MEMO

Date: April 22, 2009

Subject: Notice of Application Cantieni Variance (VA-09-0006)

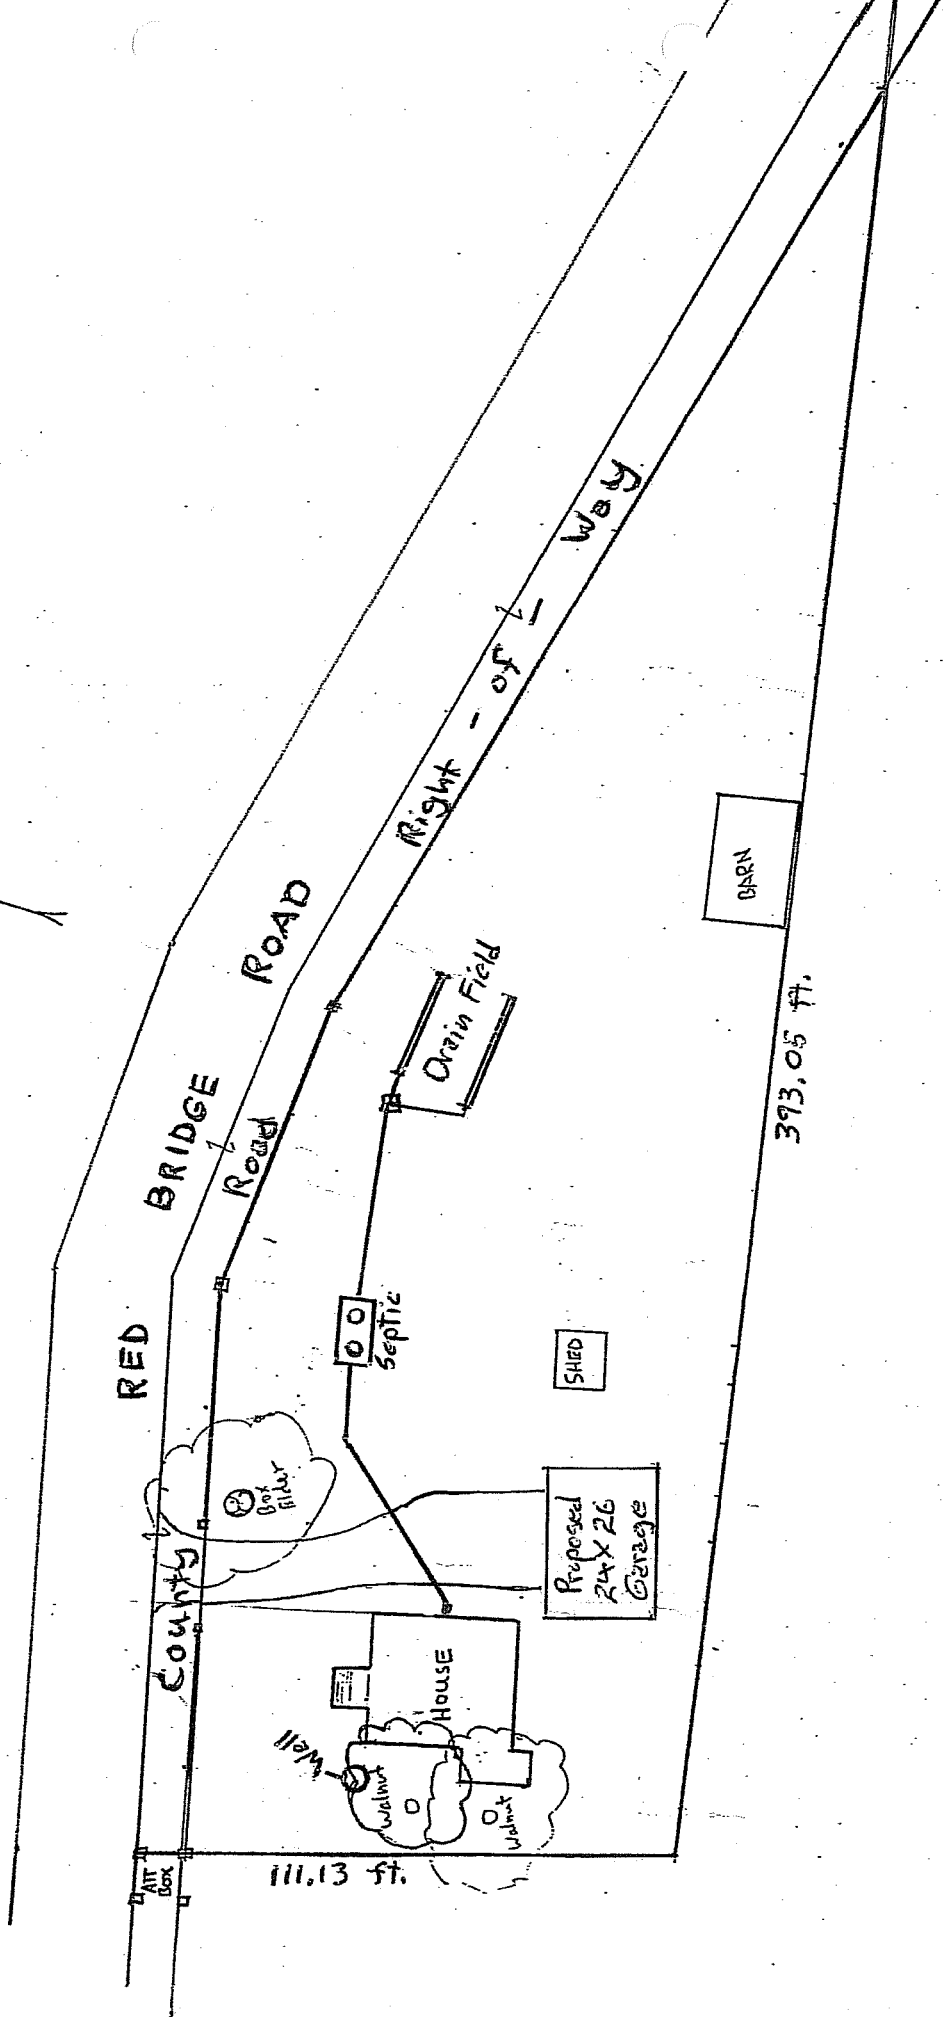
The roof of the proposed 24' x 26' garage structure should be oriented so that snow does not slide onto the adjacent property.
